**Our Case Number:** ABP-314056-22

**Re:** Liffey Valley to City Centre Core Bus Corridor Scheme.  
Fonthill Road to High Street all in the County of Dublin.

**BUS CONNECT PROPOSALS IMPACT ON Dublin 8 area –****Liffey Valley to City Centre Core Bus Corridor Scheme.****KA29N.314091**

Programme Title: BUSCONNECTS DUBLIN CORE BUS CORRIDORS INFRASTRUCTURE WORKS			
Drawing Title: LIFFEY VALLEY TO CITY CENTRE CORE BUS CORRIDOR SCHEME TRAFFIC SIGNS AND ROAD MARKINGS			
Drawing File Name: BCIDB-JAC-TSM_GA-0007_XX_00-DR-CR-0024	Sheet Number: 24 of 28	Status: A	Rev: M01

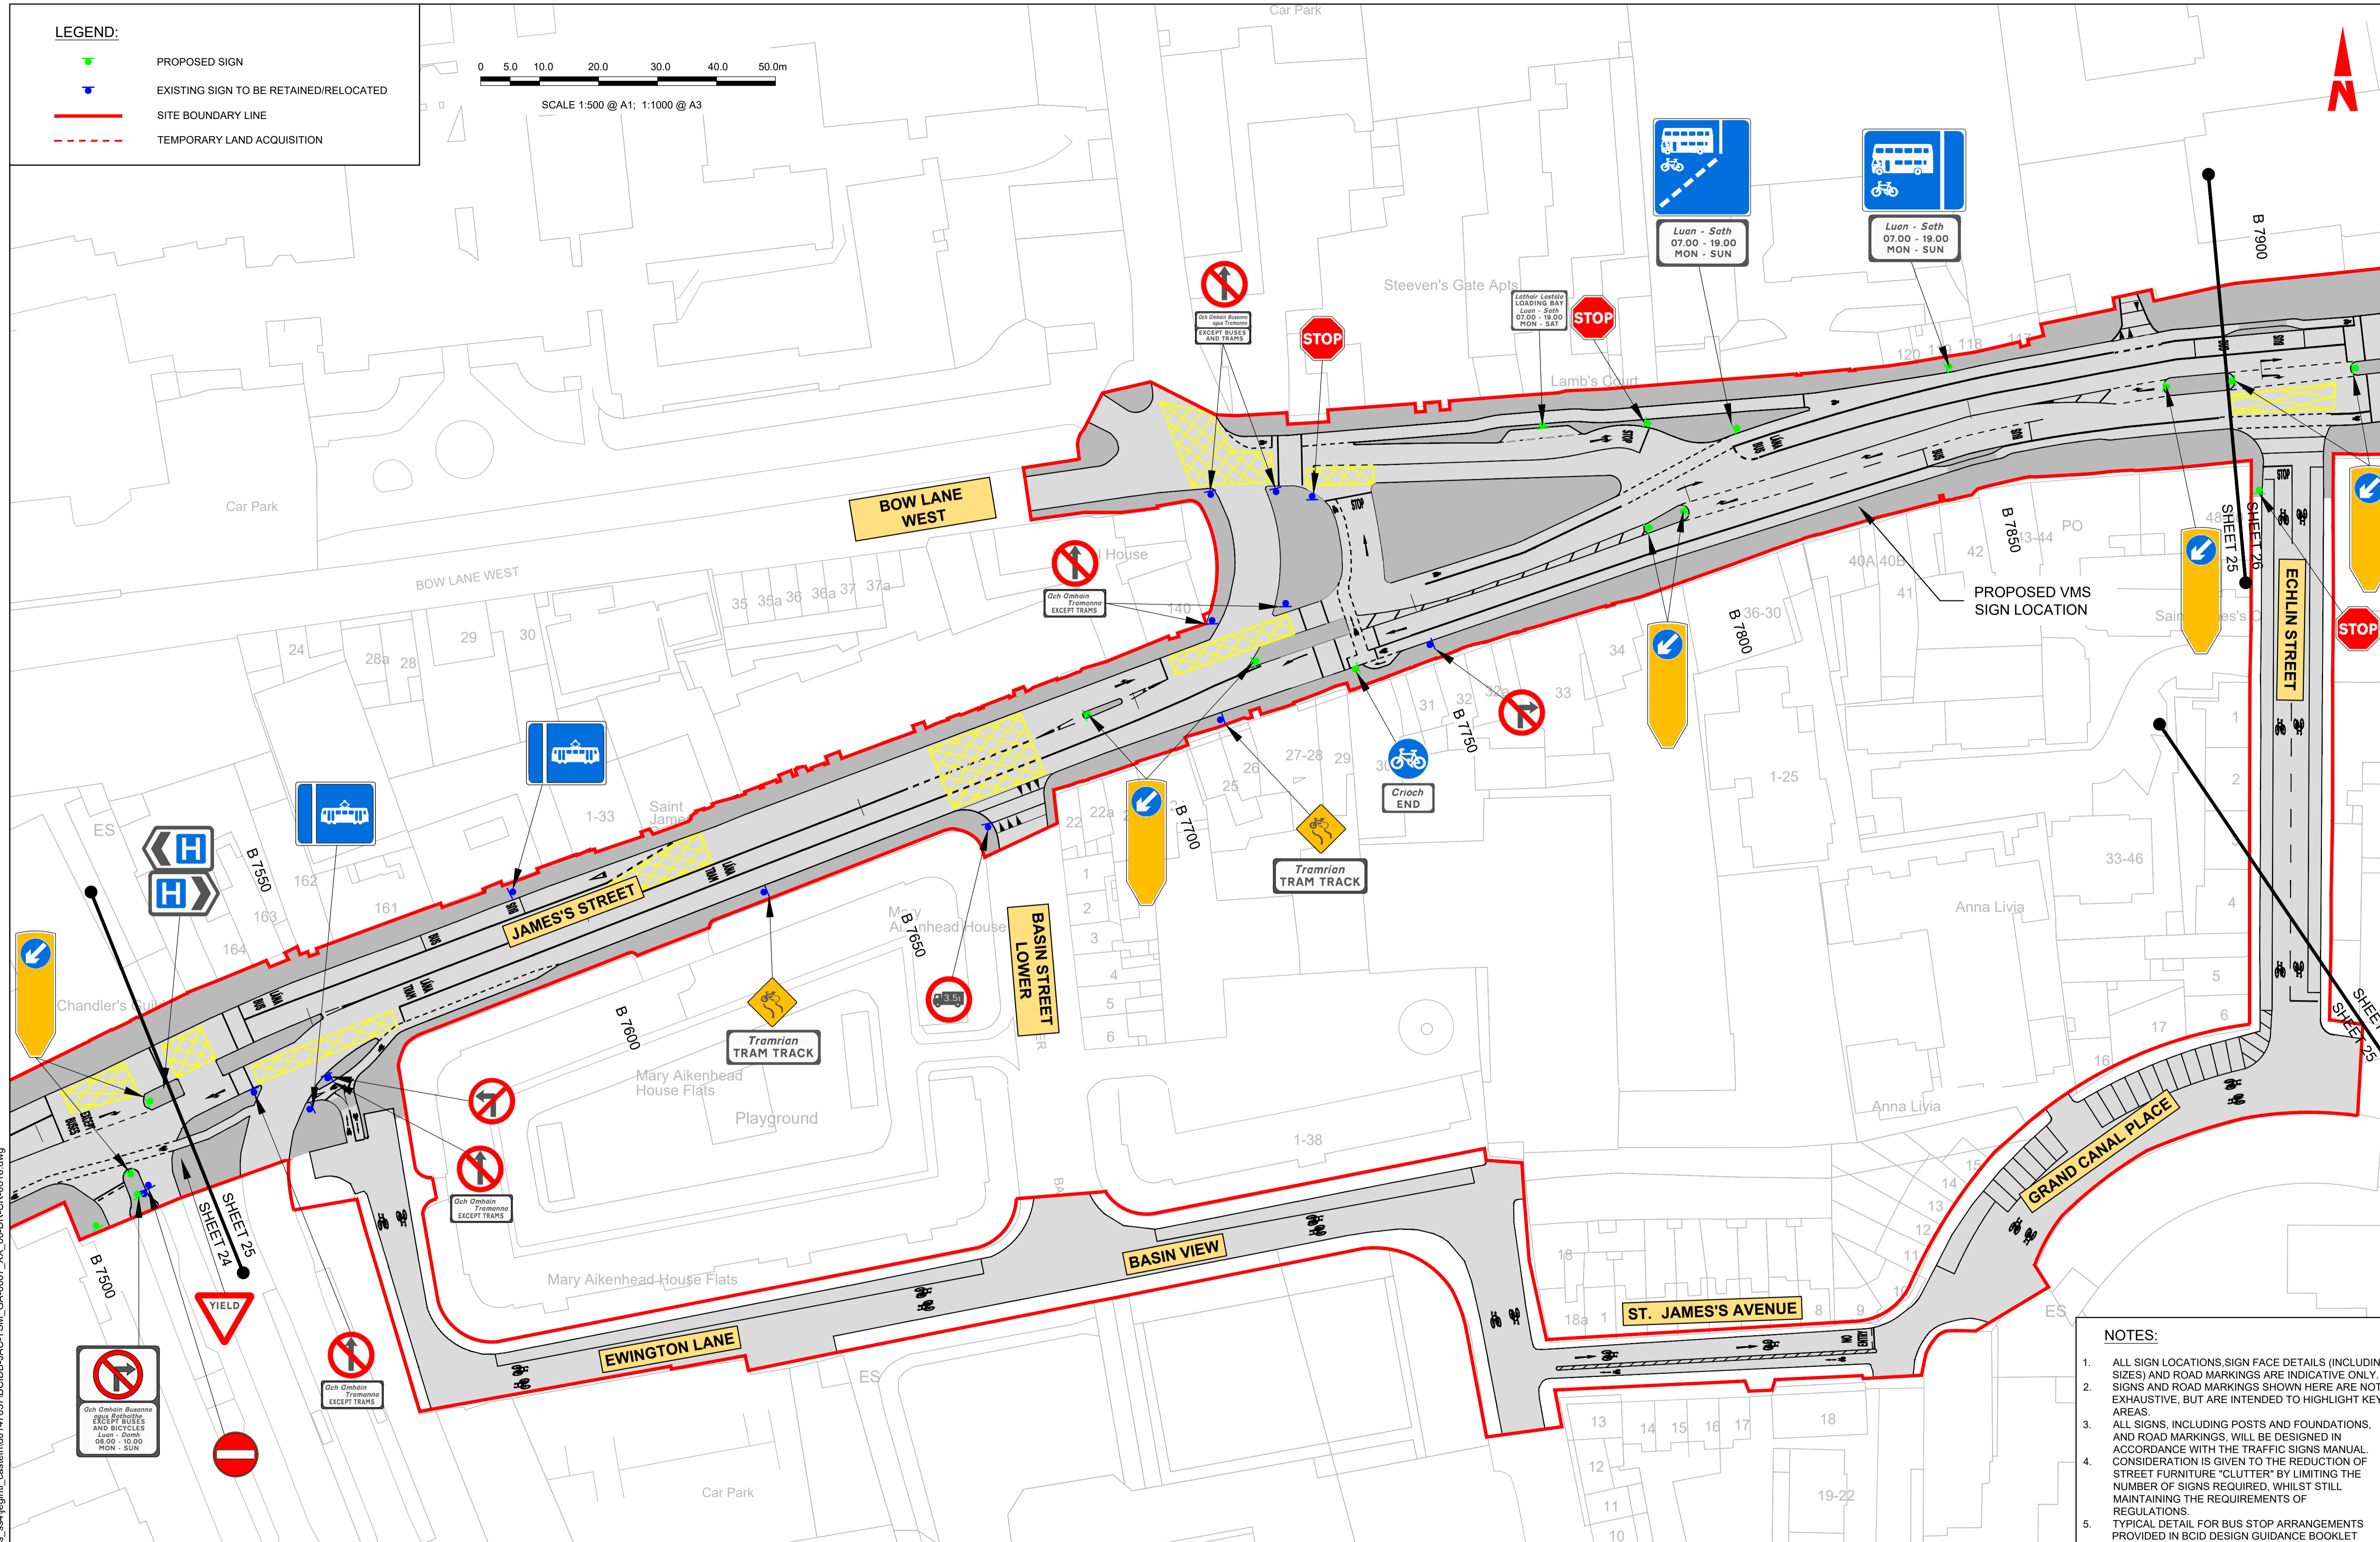
9. Drawing no BCIDB-JAC-GEO-GA-0007-XX-OO-DR-CR-0024 ( sheet no 24 of 28) is flawed as there is no reference to a Bus Gate at SJH entrance. Bus Gate at Mount Brown is shown on sheet no 23 of 28. This is a fundamental omission and ought to render the application invalid.
